**CITY OF ALBUQUERQUE
Planning Department
November 14, 2007
DRB Comments
2nd Set**

PROJECT #1006922

RE: Lot 27-A/spbp....second set of comments

RE: Lot 27-A/spbp & minor plat

SITE DEVELOPMENT PLAN FOR BUILDING PERMIT

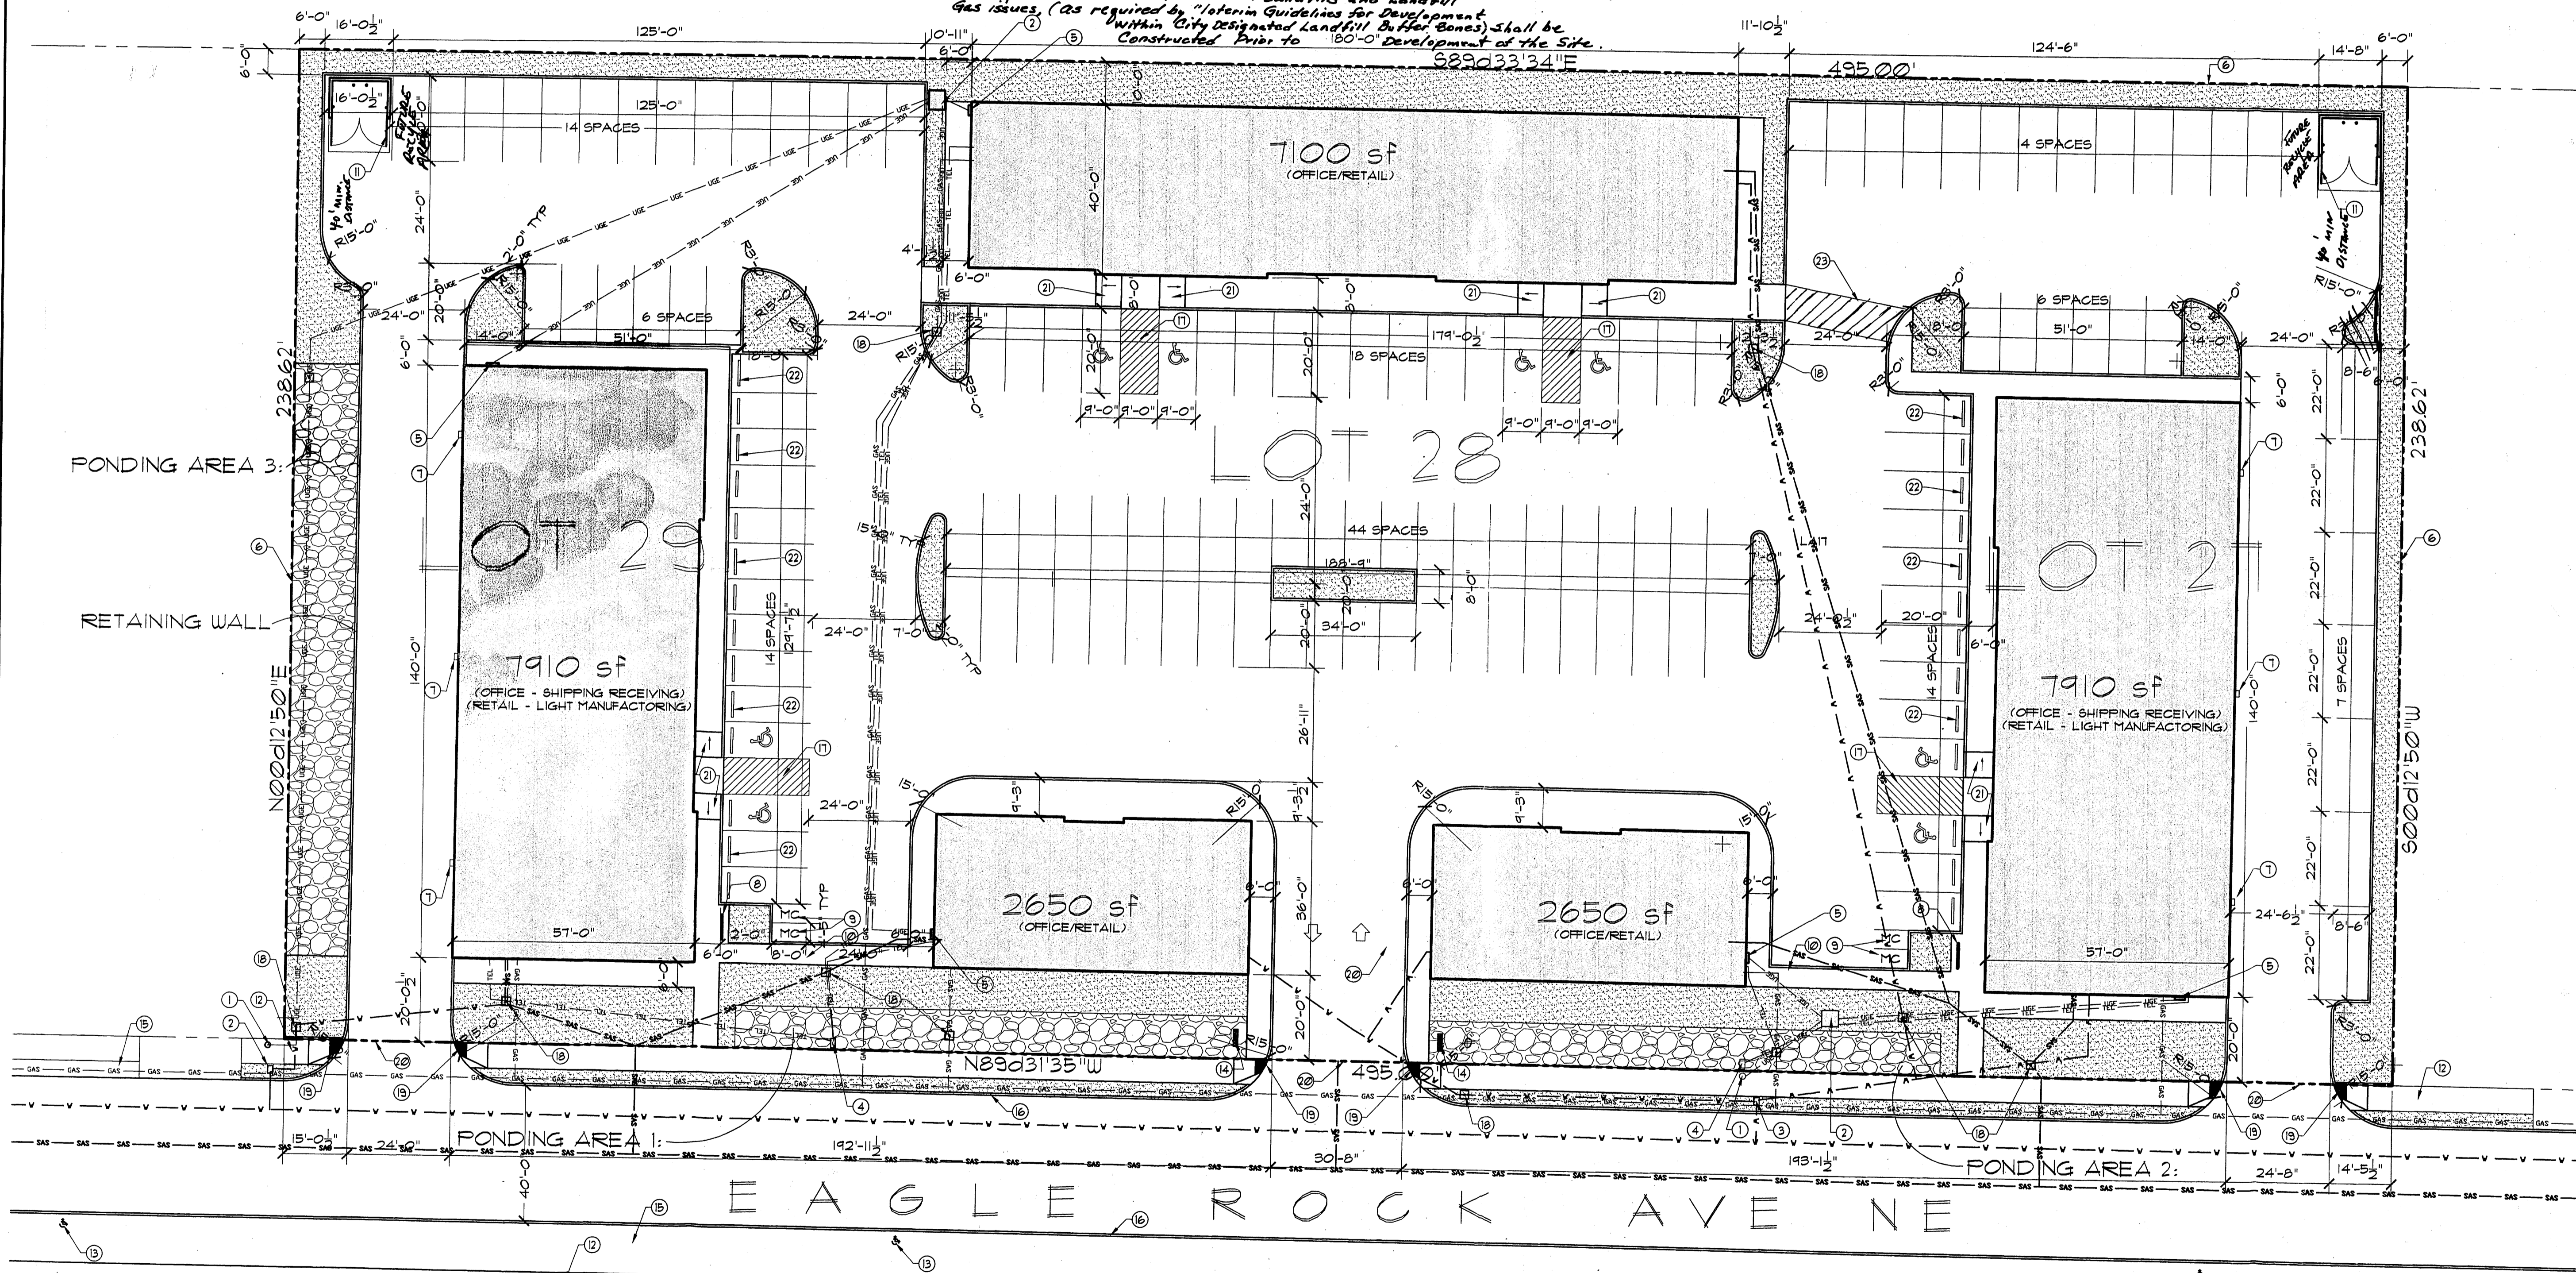
1. The colors of the monument signs and size & colors of the letters and what the sign will say are required.

1. Remove the existing lot lines from the site plan.
2. Show the proposed use on each building footprint on the site plan.
3. Is the chain link fence new or existing?
4. There are 2 monument signs indicated on the plan but none of the Checklist required information.
5. Section 14-16-2-19(E) of the Zone Code requires a twenty foot front yard setback and ten foot back yard setback of the building from the property line. This plan does not meet those requirements.

LANDSCAPE PLAN

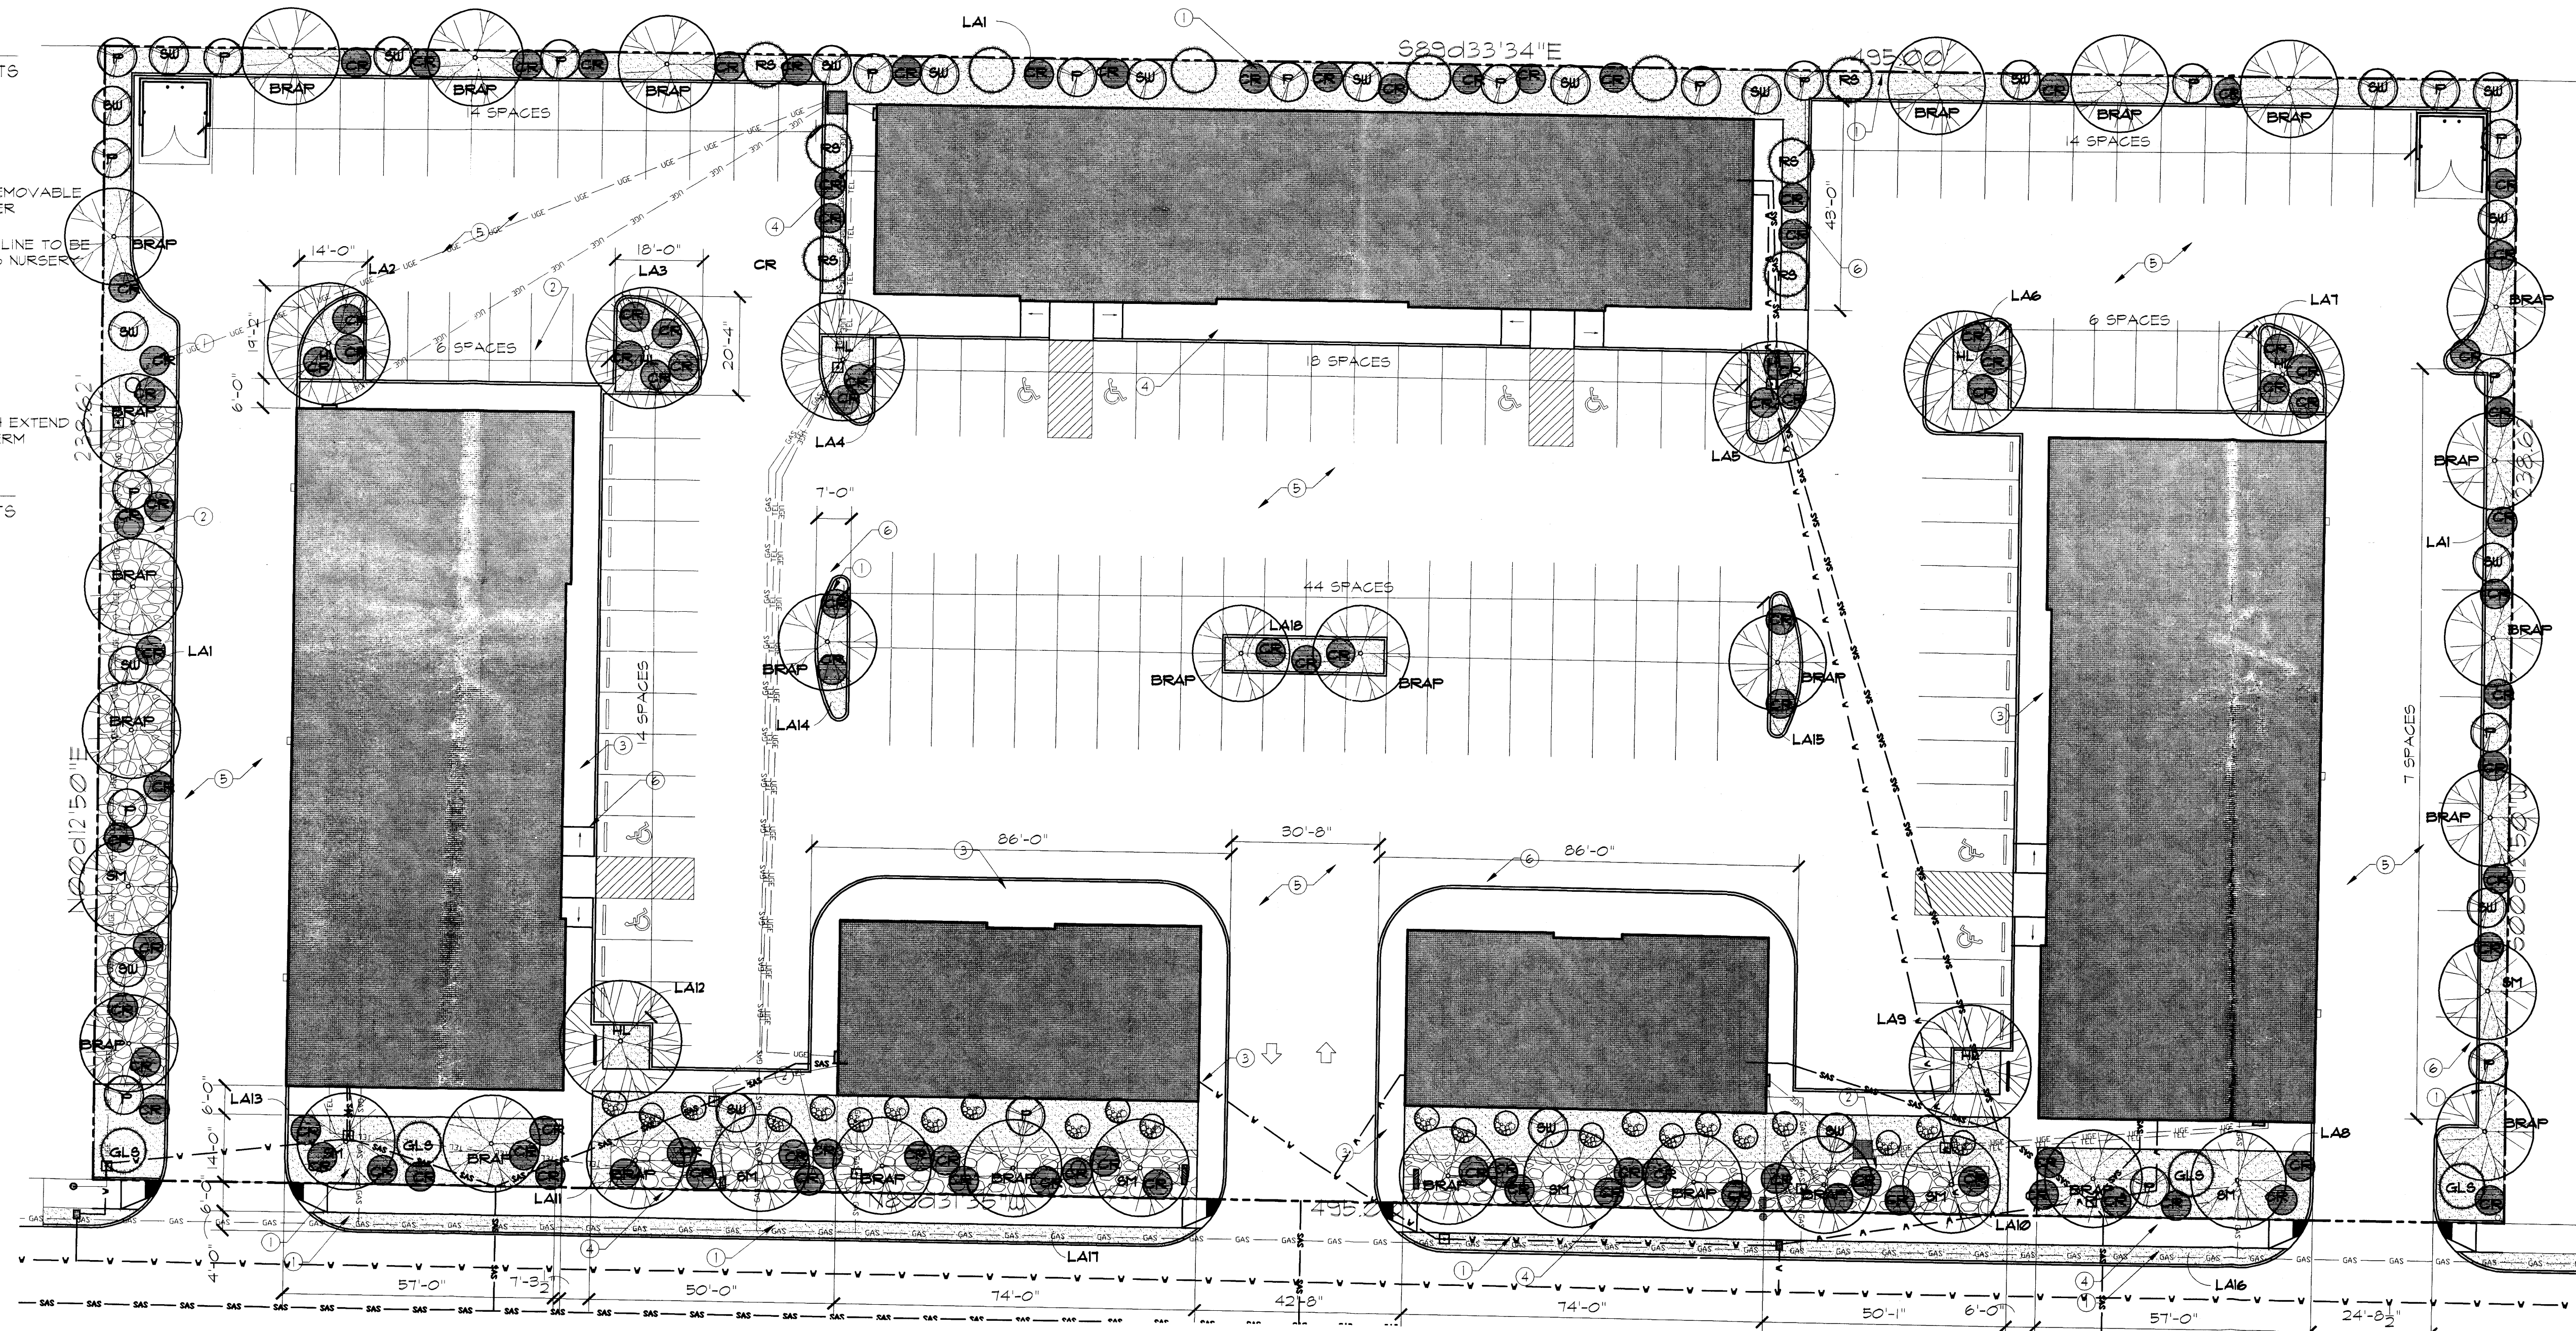
1. The required number of street trees is okay. However, at least 3 different species are required to lessen the possibility of disease killing them all and to provide variety.

2. The landscaping in the plan still will not cover 75% of the area when it is at maturity. There are not yet enough plants to provide a buffer or screen on all 4 sides.

3. The easements are still not shown.

✓ 4. The square footage of each landscaped area is still not on the plan.

5. The ponding areas can and should have plants in them as well.

6. The two trees in the middle parking area should have a larger area with gravel to allow sufficient root spread and watering without uprooting the concrete. Add a 4 foot wide rectangular gravel area between the 2 trees. The spaces are long enough to do so.

1. Each plant on the Plan must have its own symbol. The number of each plant must be listed.
2. The Street Tree Ordinance requires a tree along Eagle Rock for each 30 feet of frontage. This means 13 trees are required.

3. The landscaping in the plan is required to cover 75% of the area counted in the landscaping calculations. The plants are too sparse to reach this goal. Plus the North I25 Plan (Page 54) requires the landscaping on all sides to act as buffers. This landscaping is not dense enough. The buffers are supposed to be a combination of trees, shrubs and vegetative ground cover.

4. The easements on the site plan must be shown on the Landscape Plan as well.

5. The crushed rock must be at least 3" deep and the type must be identified.

6. A statement is required saying the owner will maintain the irrigation system.

7. The square footage of each landscaped area must appear on the Plan.

8. The 10 foot landscaping buffer on the front does not meet the sector plan requirements. See Page 54.

9. No parking space may be more than 50 feet from a tree. See Page 55.

sheet no:
A-1.0

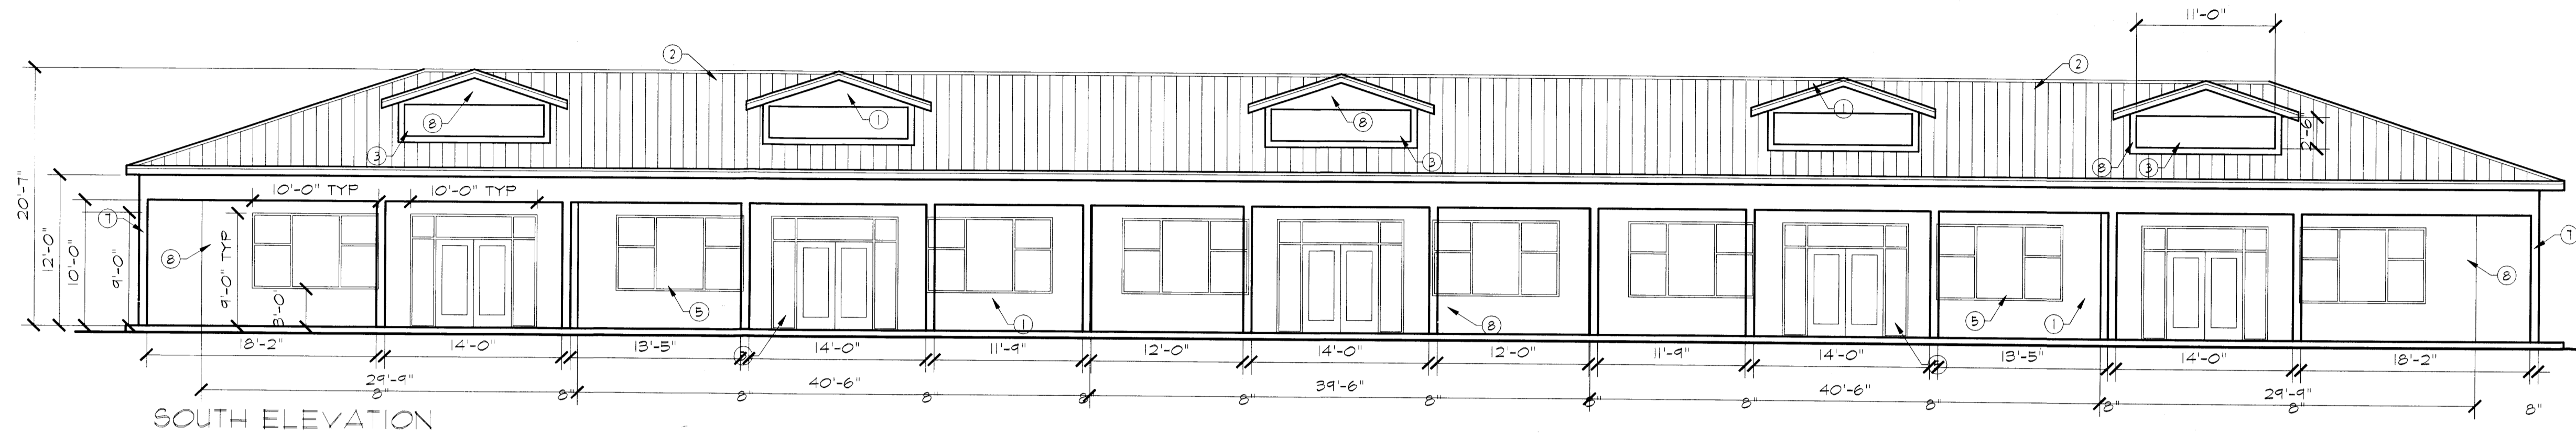
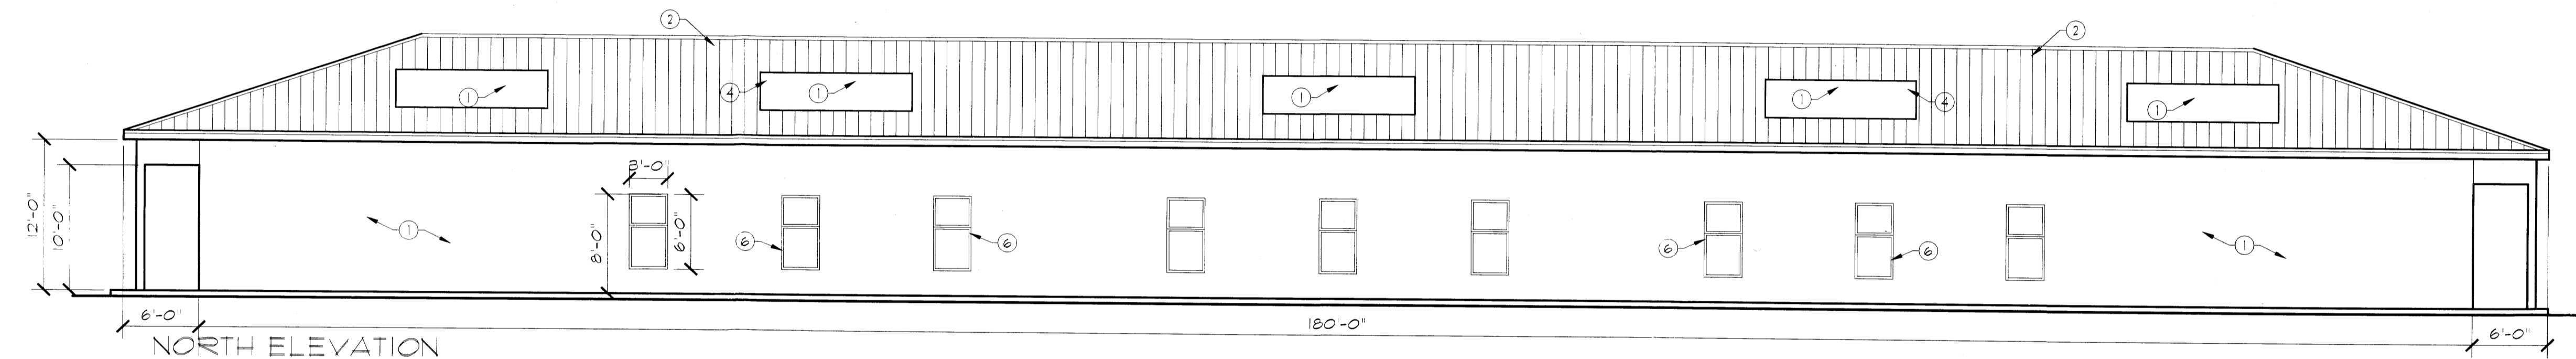
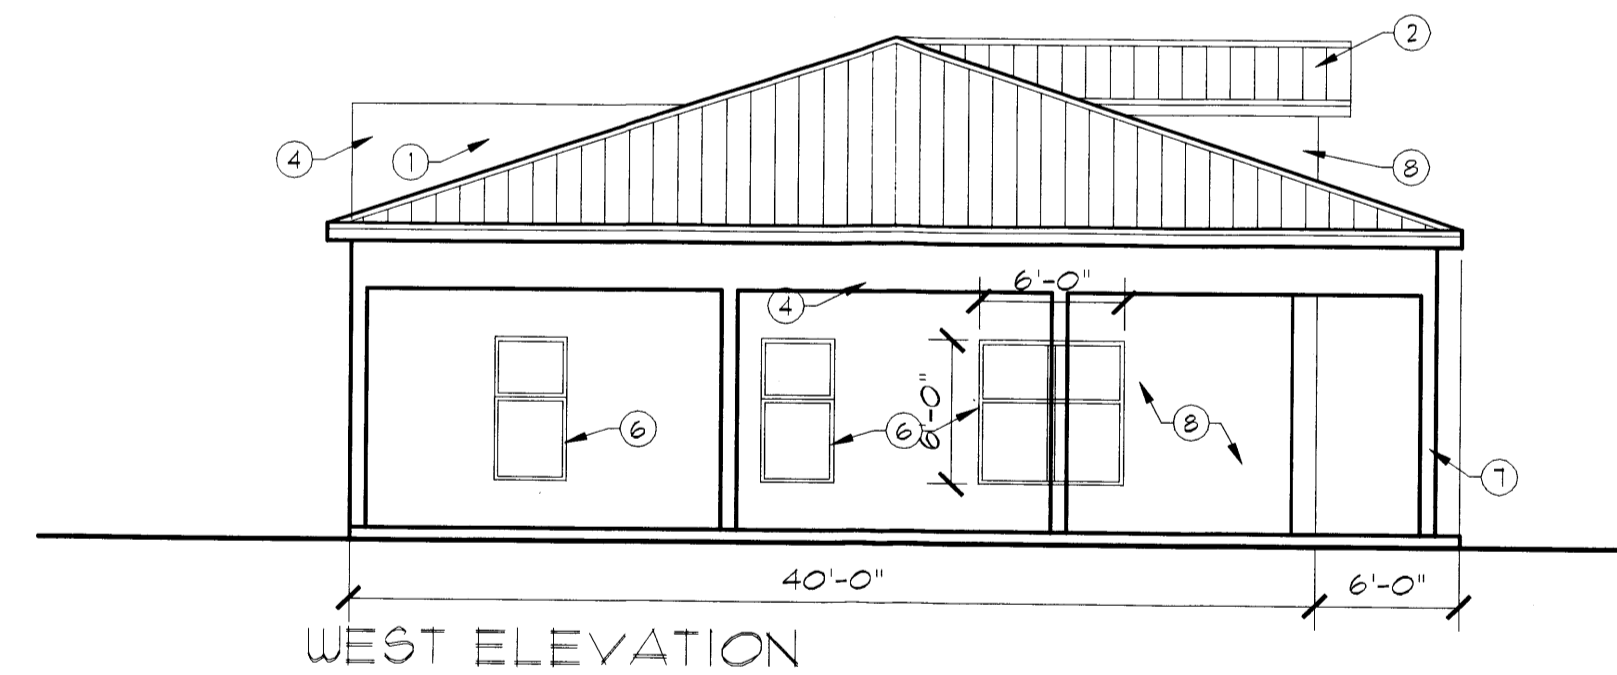
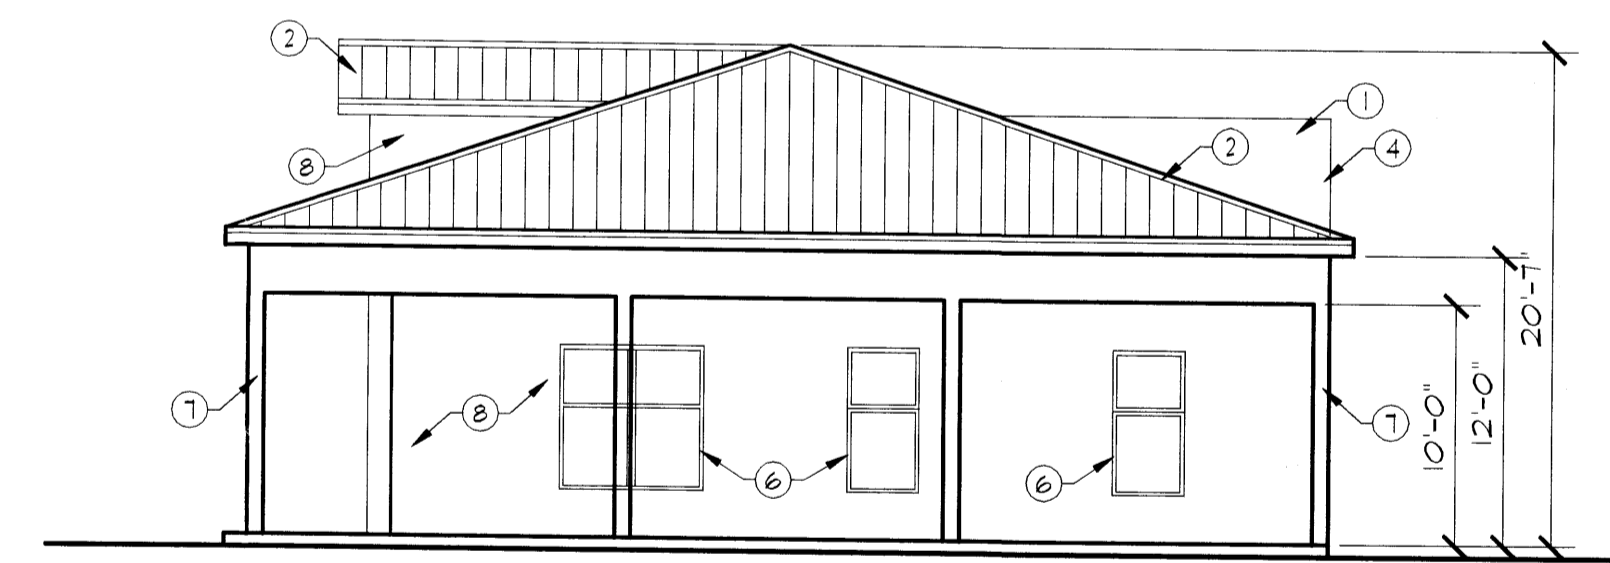
6. The building elevations are still not complete. The color renderings do not satisfy this requirement. Consult the SPBP Checklist for the requirements.

1. The building elevations sheets are not complete. The SPBP Checklist indicates required elements.

2. Remove the floor plans. They are not part of the DRB approval process.
